Re: SSD 13_6123 USYD Campus Improvement Program 2014-2020 for Camperdown-Darlington Campus

01 ENGINEERING - SHEPHERD STREET ELEVATION PROPOSED

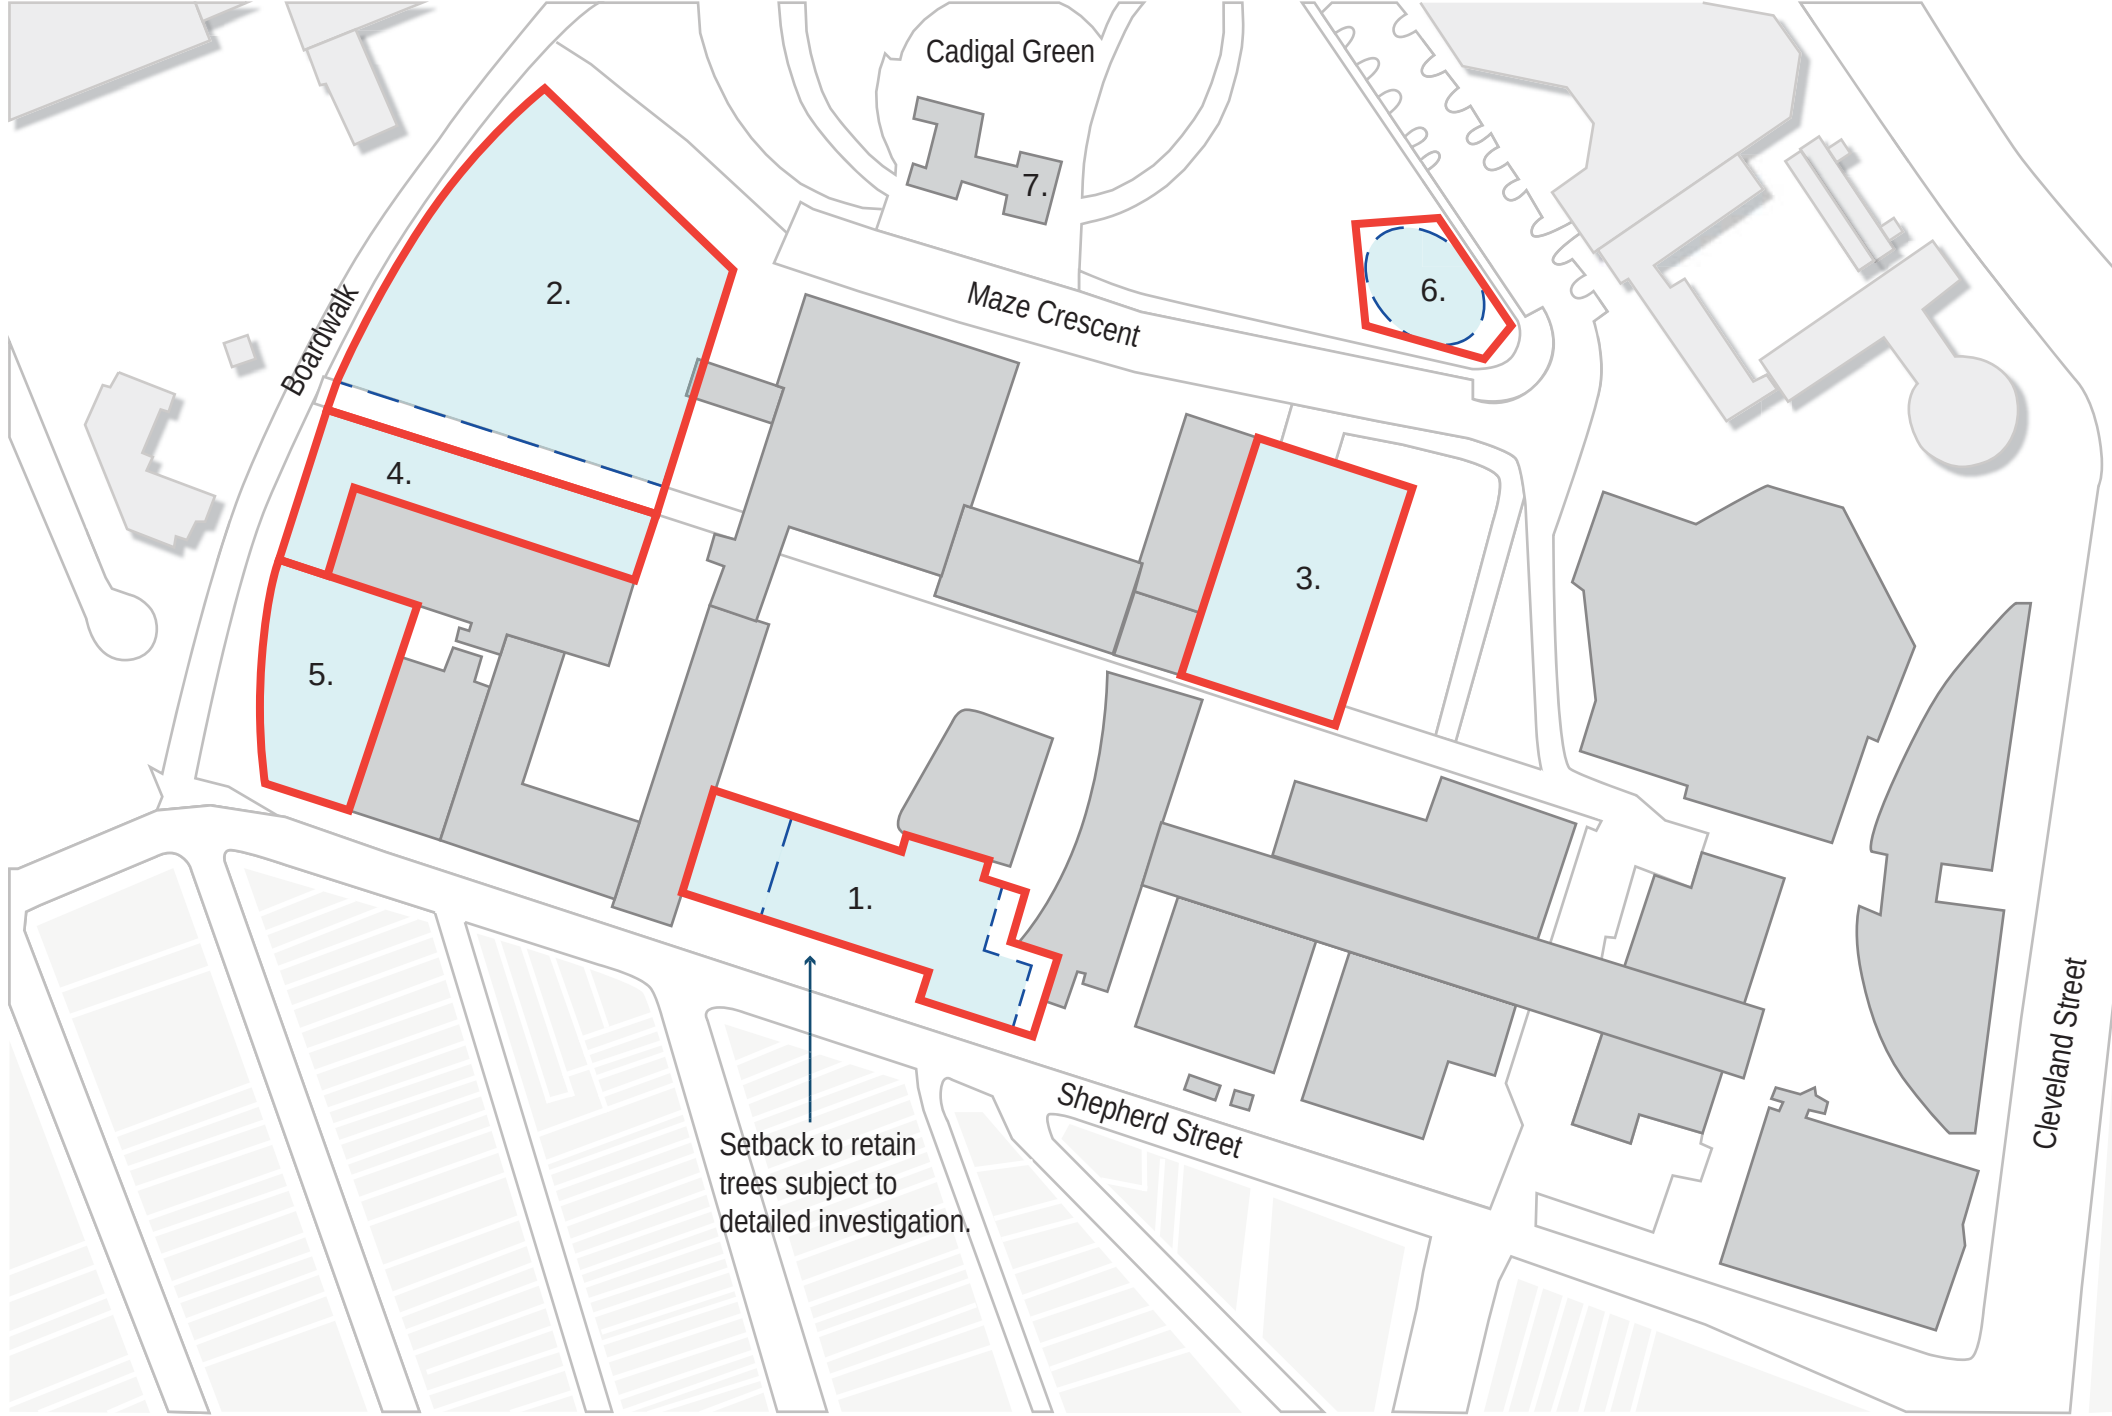
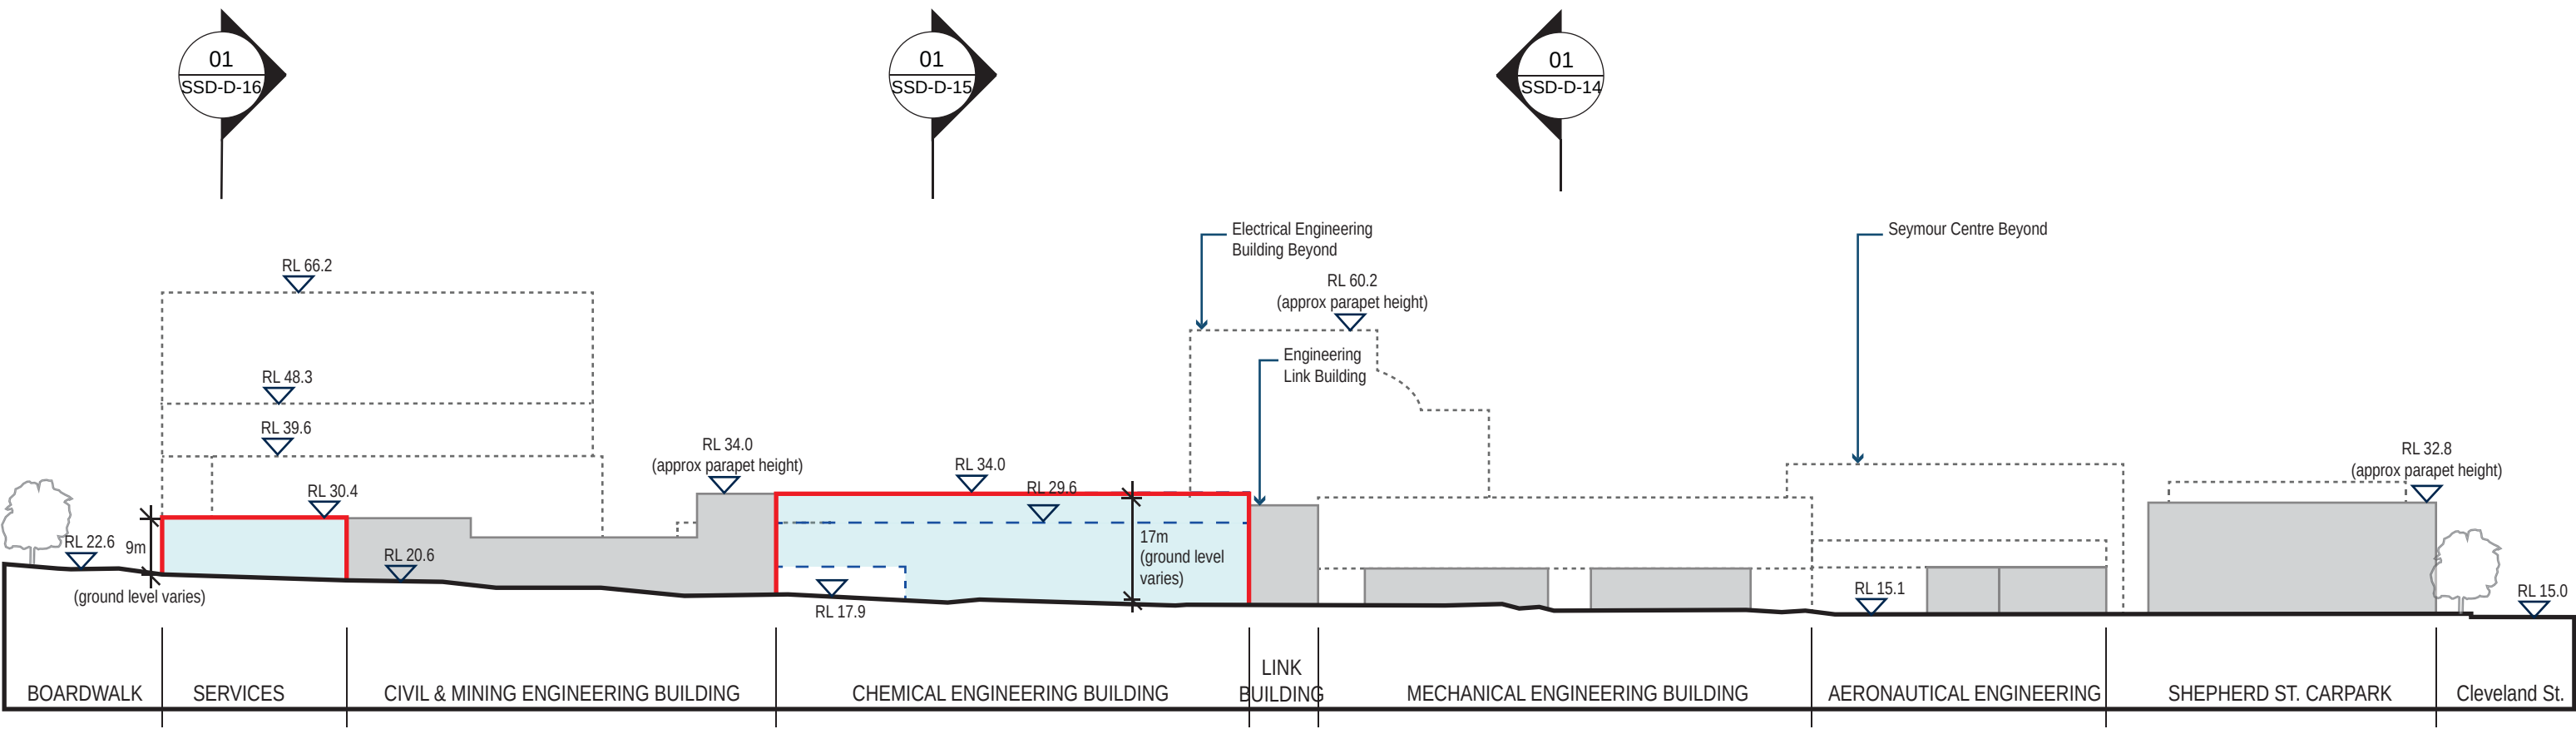
2. We object to the destruction of the Darlington Eucalypt Grove in Shepherd Street and replacing it with a 3 storey building overlooking resident's houses at odds with the University's Ecological Assessment recommendation: **"Avoid removal of mature trees and protection of trees in proximity to building/refurbishment sites."**

01 DARLINGTON TERRACES - PROPOSED ENVELOPE PLAN

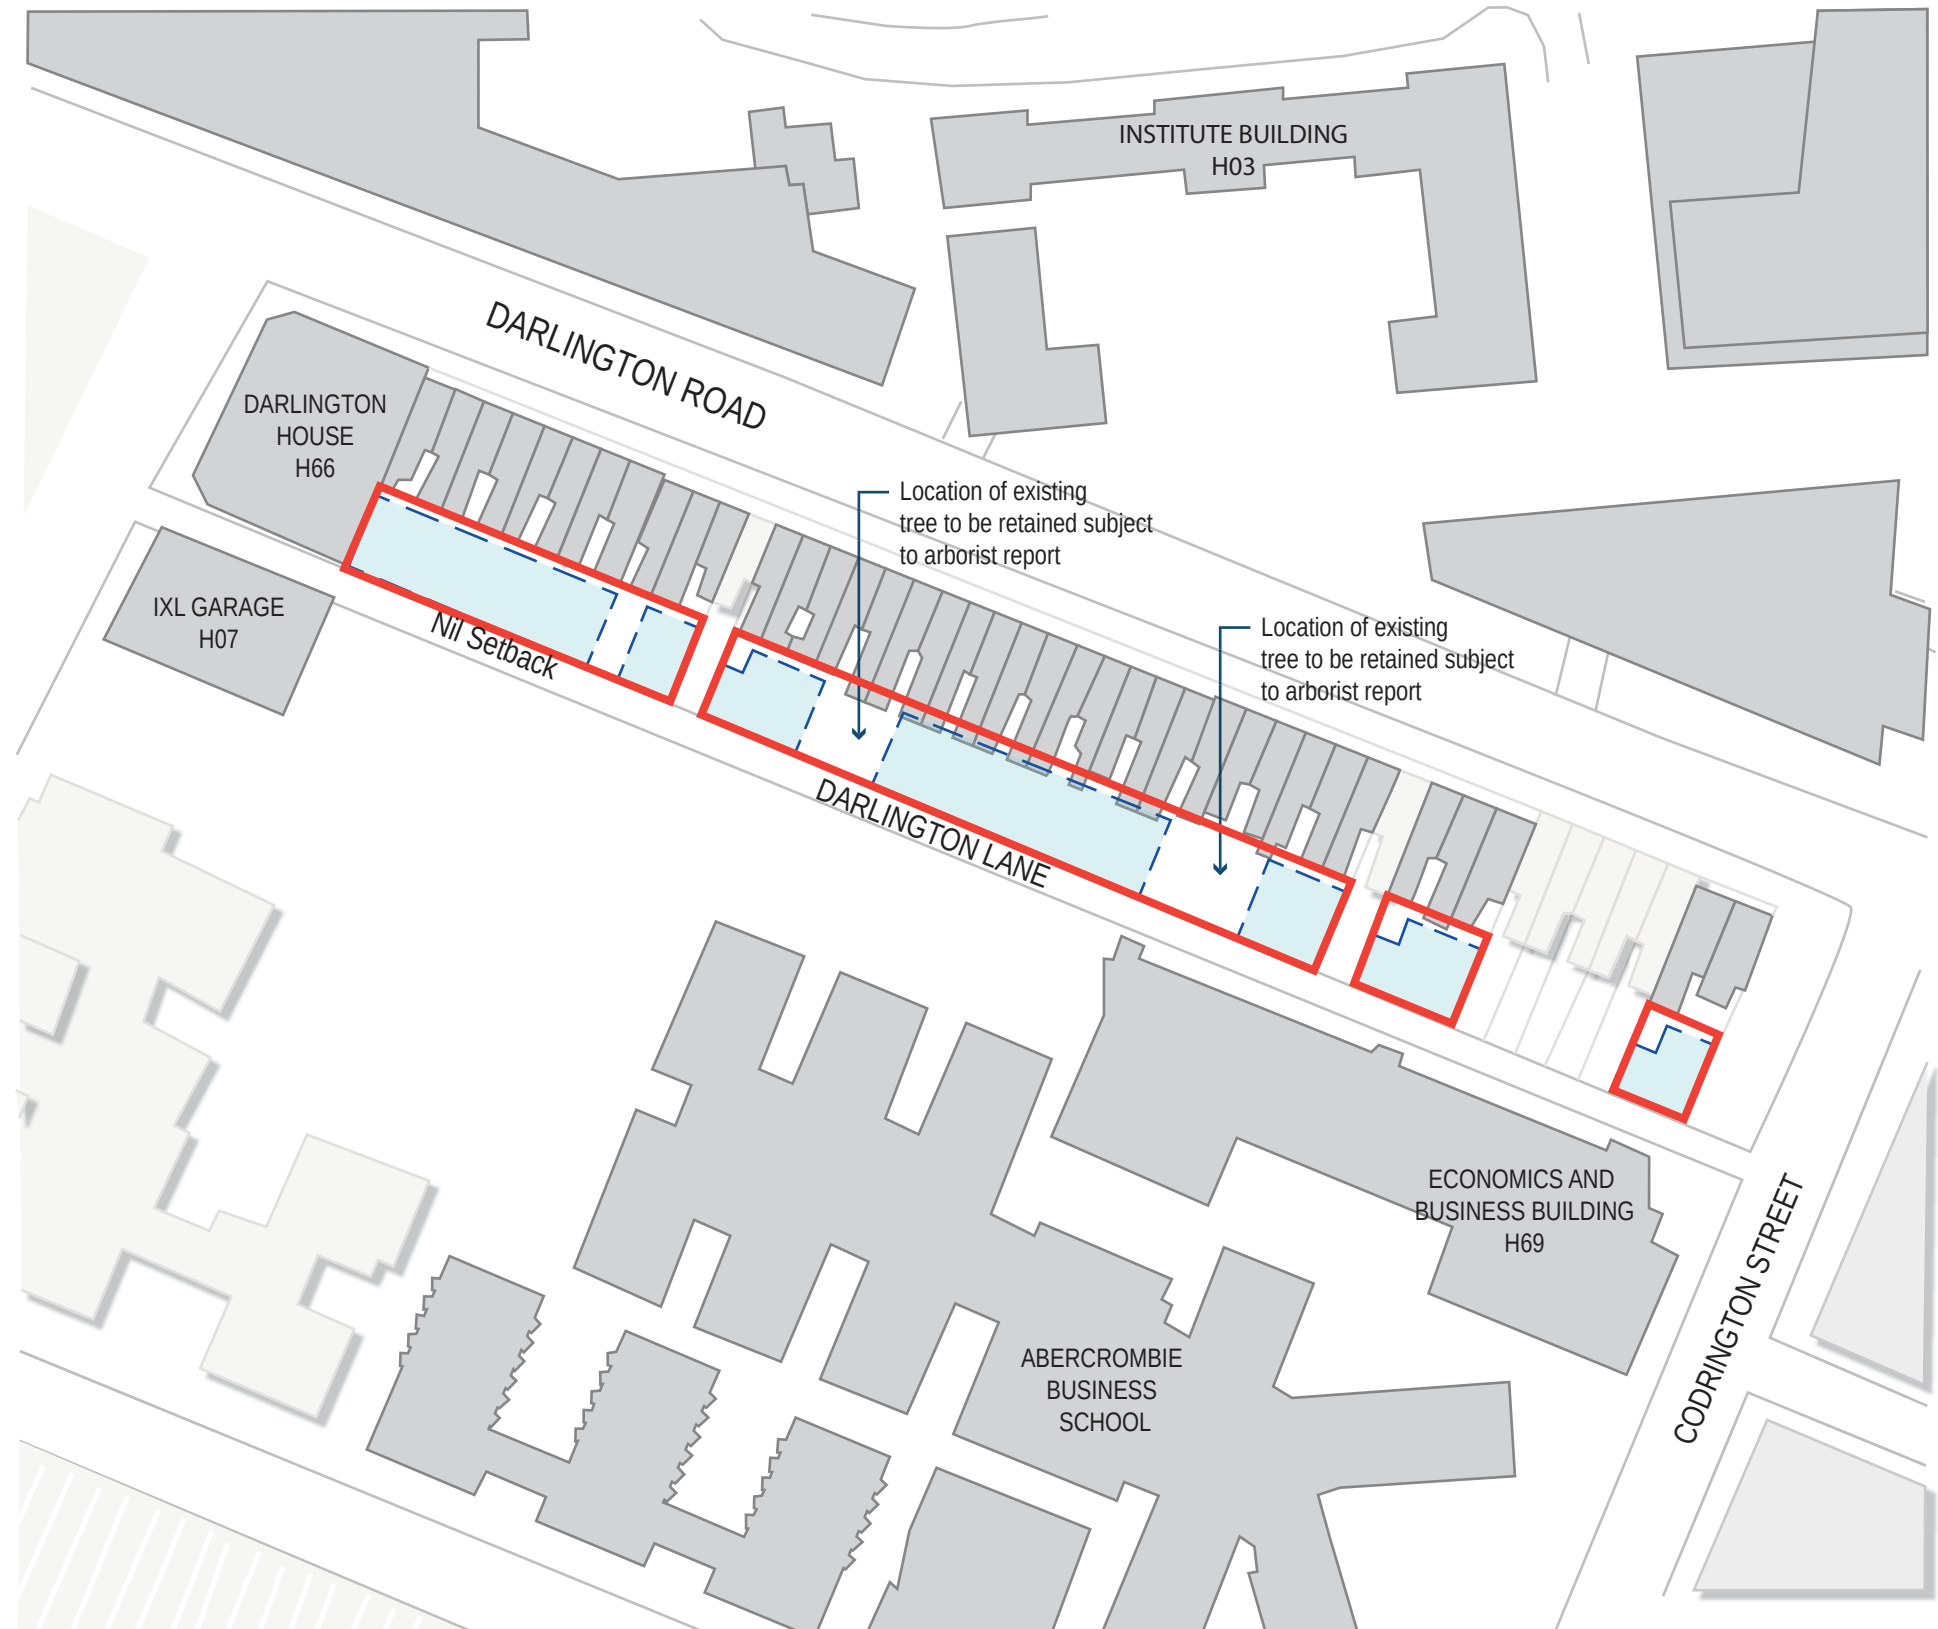
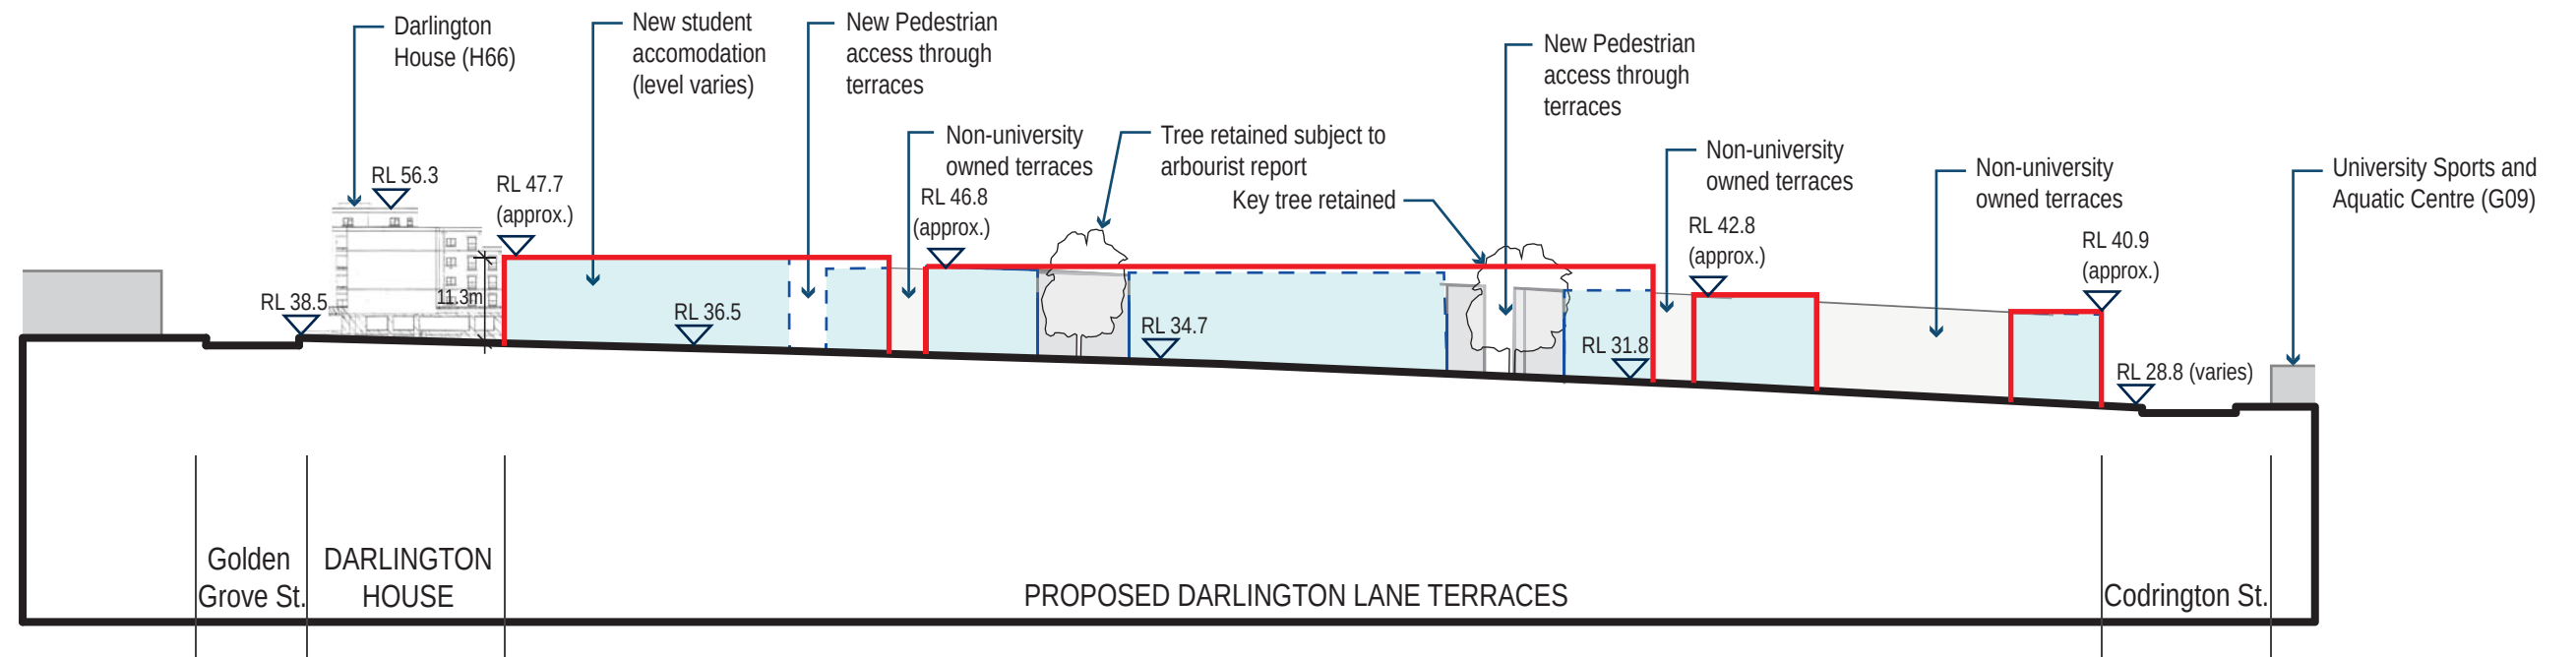
5. We object to the University's proposal to completely infill the backyards of every heritage listed terrace house from 86 – 130 Darlington Road with 3 storey extensions. The National trust has given these terraces an "A" rating – "highly intact". The University should not be allowed to degrade the heritage value of these terraces which are very close to the Golden Grove Conservation Area.
